May 4, 2020

Re: Addendum to Pedestrian Level Wind Study
400 Albert Street, Ottawa
GWE File No.: 19-154-CFDPLW

A100

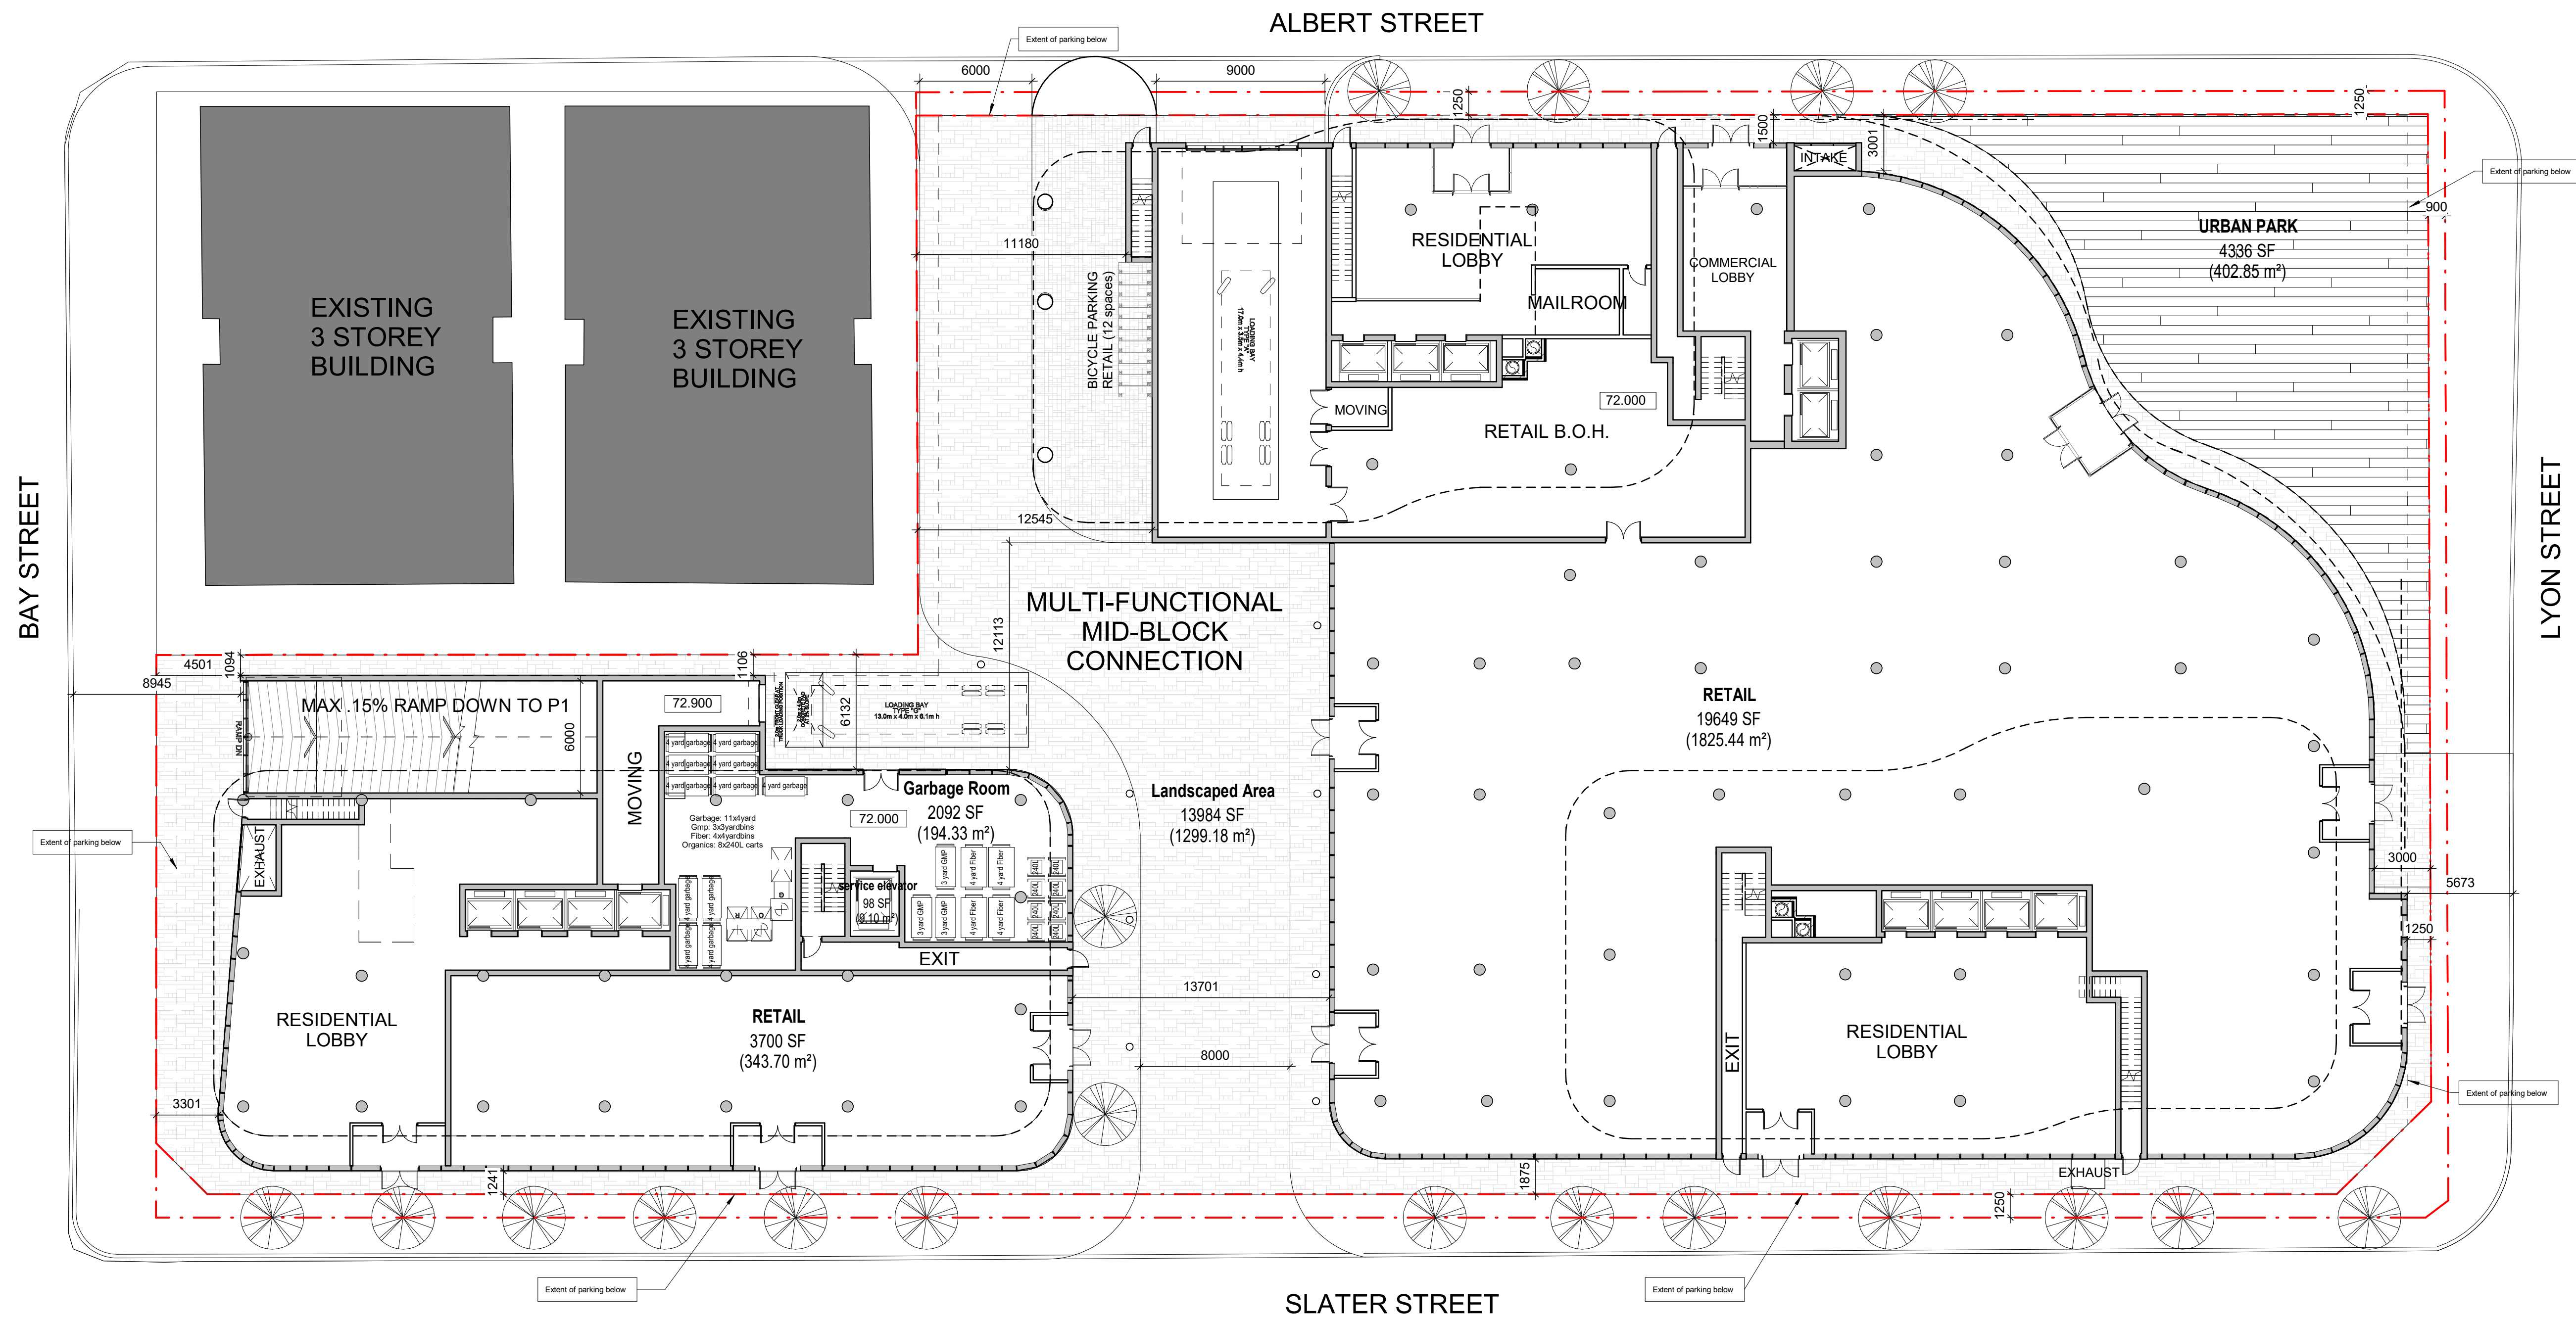
Overall, the revised design of the development retains similar characteristics to the tested configuration. At the east side of the site, Tower A at the north has increased from 18 storeys to 23 storeys, while Tower B at the south has decreased from 33 storeys to 29 storeys. Across the mid-block connection, Tower C at the southwest corner of the site has decreased from 38 storeys to 35 storeys. The three-storey podium connecting Tower A and Tower B now successively steps back from the west, creating a terraced design. Above the podium levels, Tower A features increased terracing on the east elevation, while Tower B now steps back from the west with increasing elevation (previously stepped back from the north). The interior layouts of the ground floors have also been modified somewhat, with building entrance locations correspondingly reorganized.

With regard to pedestrian level wind conditions, the revised building heights and forms are not expected to have a significant impact on pedestrian wind conditions at-grade as reported in the original study. For the outdoor common areas at Levels 2 and 3 for the east podium, wind conditions are expected to be calm and suitable for sitting during the warmer seasons. Overall, the results of the original study are considered applicable to the revised building design.
